CITY OF ALBUQUERQUE

**RE: Winrock Redevelopment Dave and Busters
Grading and Drainage Plan
Engineers Stamp Date 1/27/14 (J19D038)**

Based upon the information provided in your submittal received 2/14/14, the above referenced ~~Grading and Drainage~~ Plan cannot be approved for Building Permit until the following comments are addressed.

GRADING & DRAINAGE
PLAN

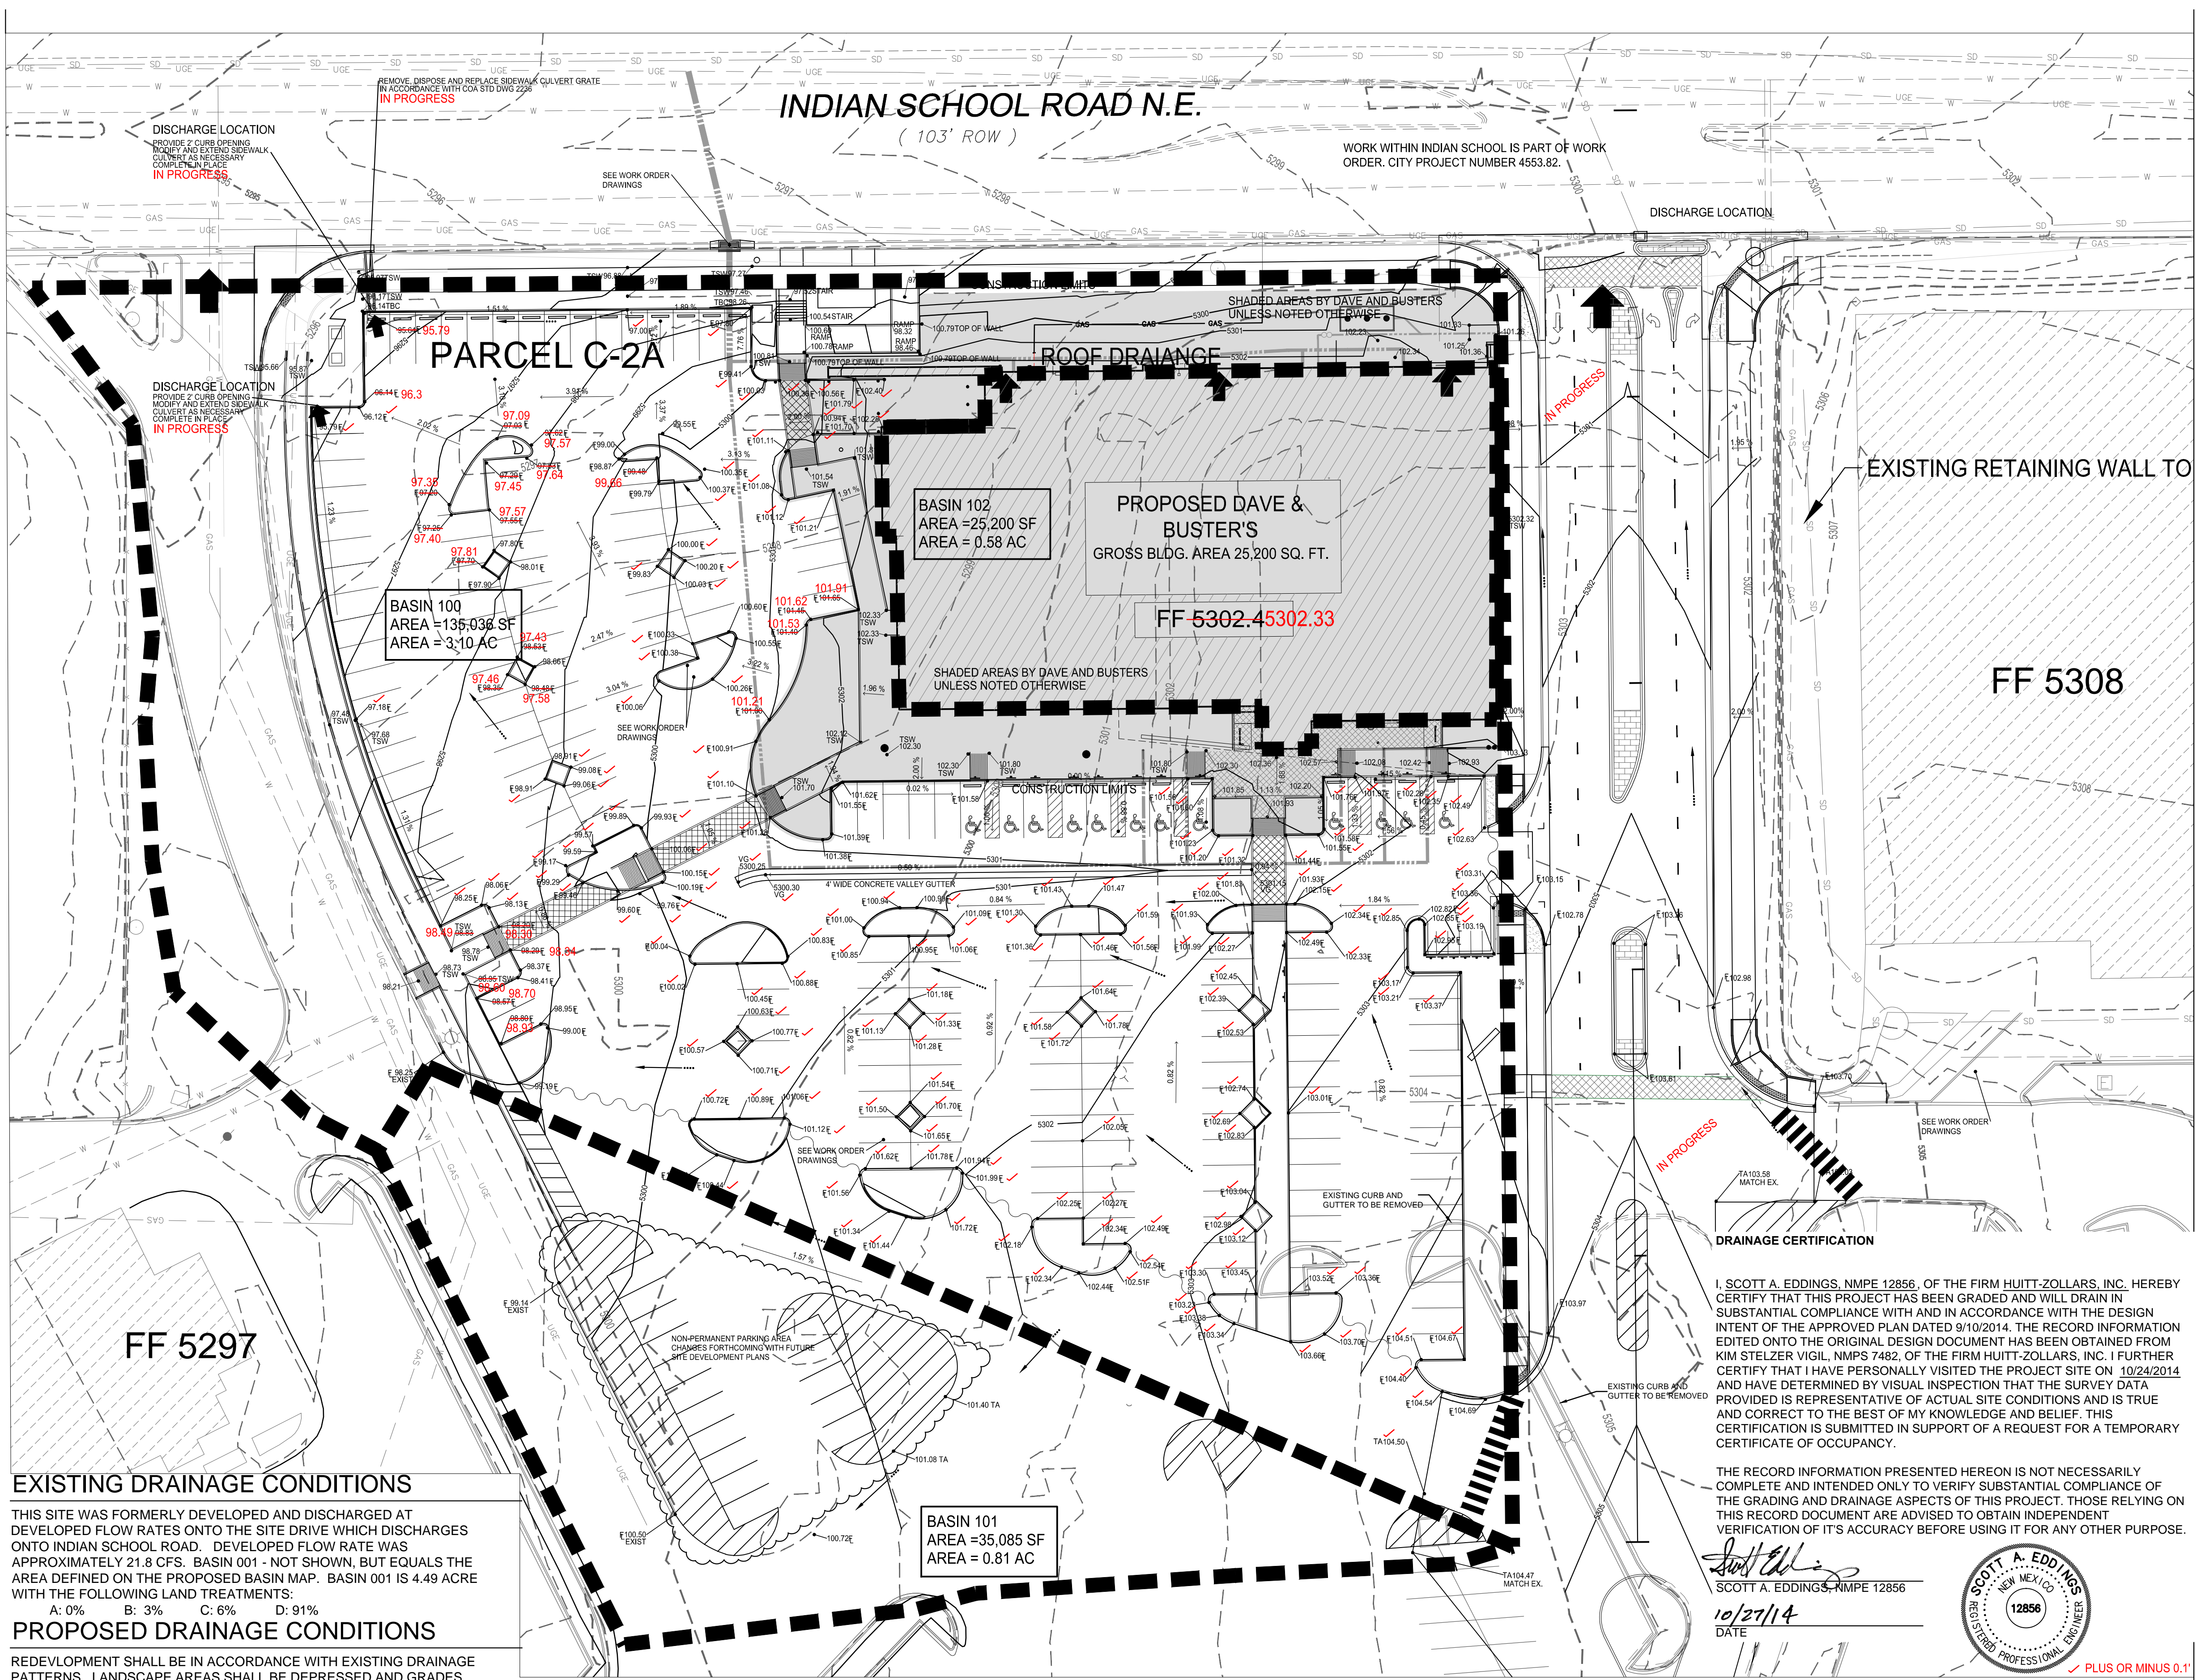
- Enlarge the utility plan to 24"x36" so it is legible or add the build notes and drainage systems to the grading and drainage plan.
- On the plan, place all drainage work that is being done in Indian School to be done by Work Order, along with replacing or repairing the sidewalk culvert. The metal cover on the sidewalk cover is in bad shape and needs to be repaired or replaced.
- Show the location of the existing inlet in the existing entrance from Indian School which is east of the site. Is this inlet being replaced, repaired or removed? Show flow lines at this location. The Island appears to be in the valley gutter, which will divert flows away from the curb and into the street. Adjust this island to prevent this situation.
